AL/96/19/HH

The proposal is for a window to an existing kitchen to an attractive property which is located within the Norton Conservation Area. The conservation area has an informal rural character with materials such as brick and flint being prevalent in the street-scene.

PROPOSED NORTH
ELEVATION

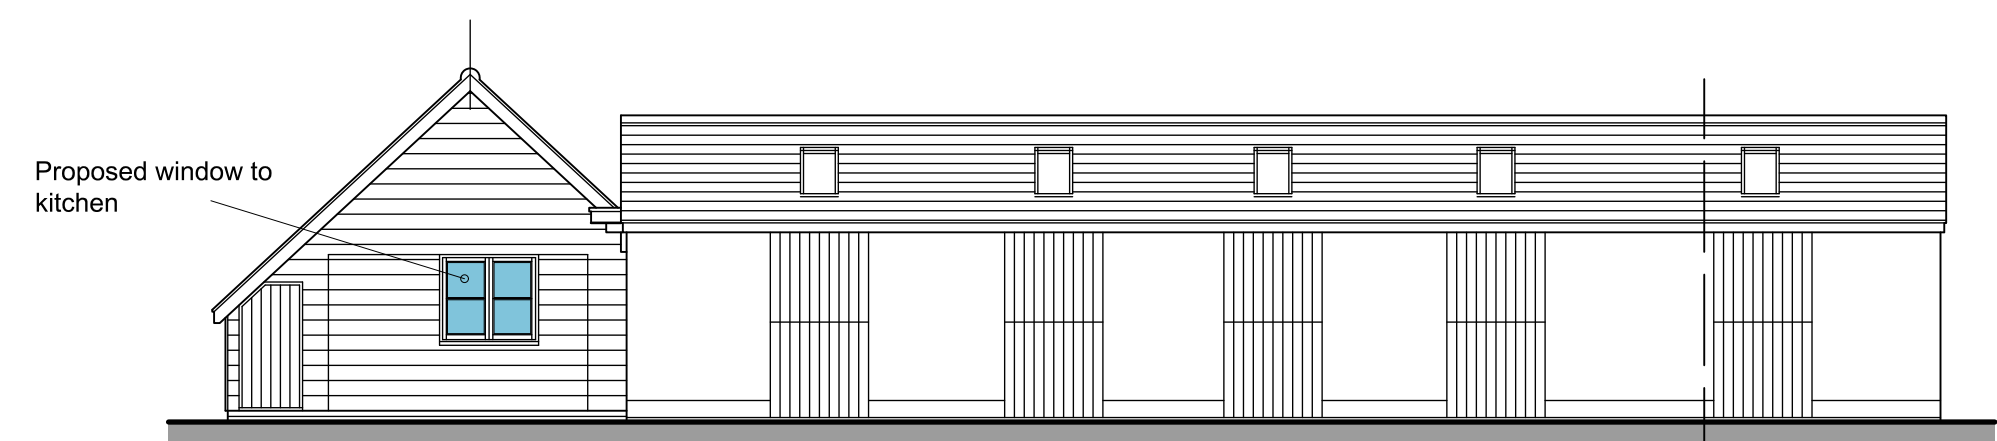
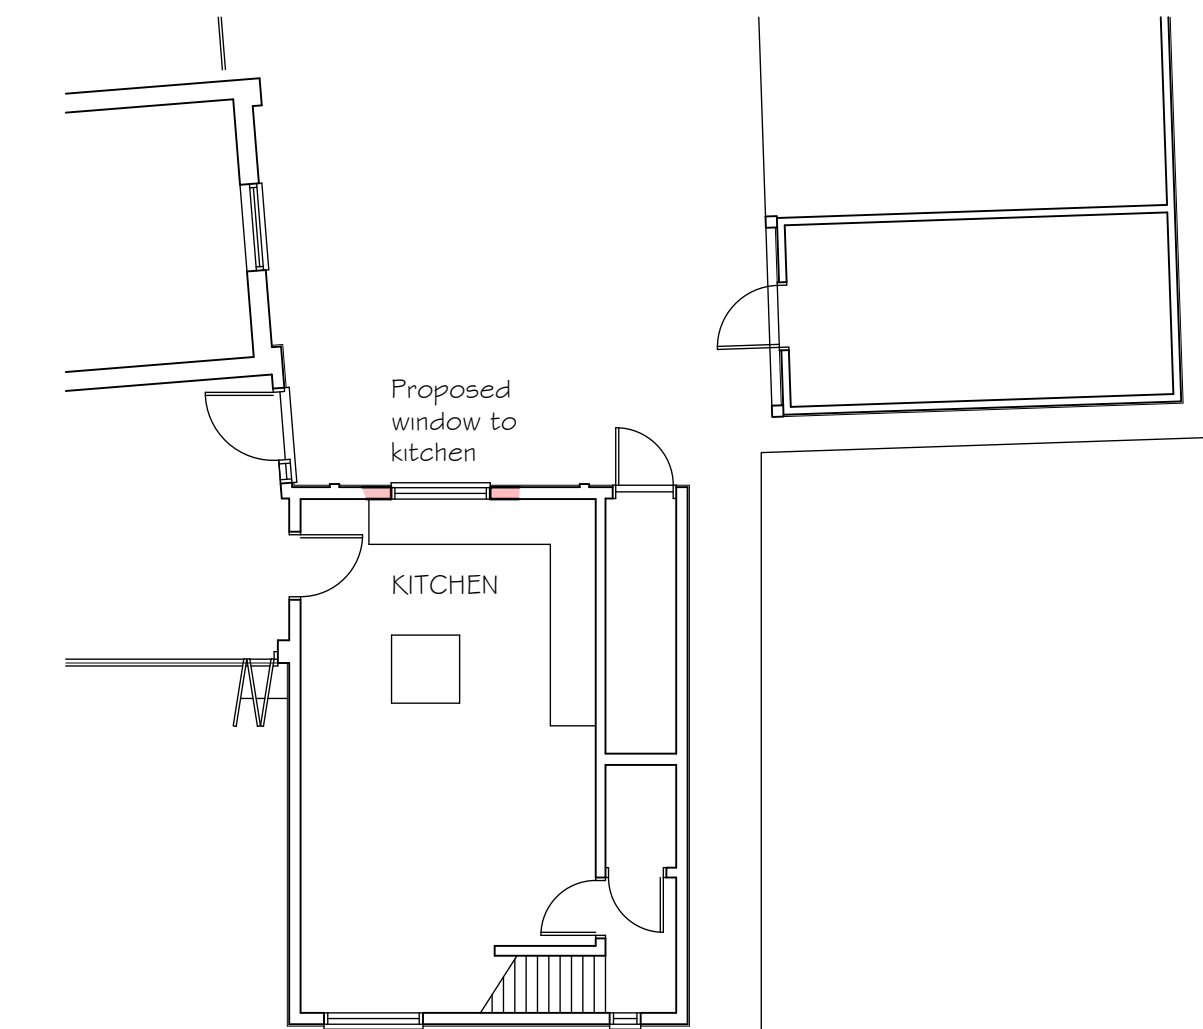
The proposal is small scale in nature and designed to provide additional light/ventilation into the kitchen space. It is suggested that it will be a stained/painted wooden window, reflective of the existing windows.

It is considered that the proposed will have a neutral impact upon the character and appearance of both the building and the conservation area. The window should match the existing ones within the building in order to ensure that it does no harm.
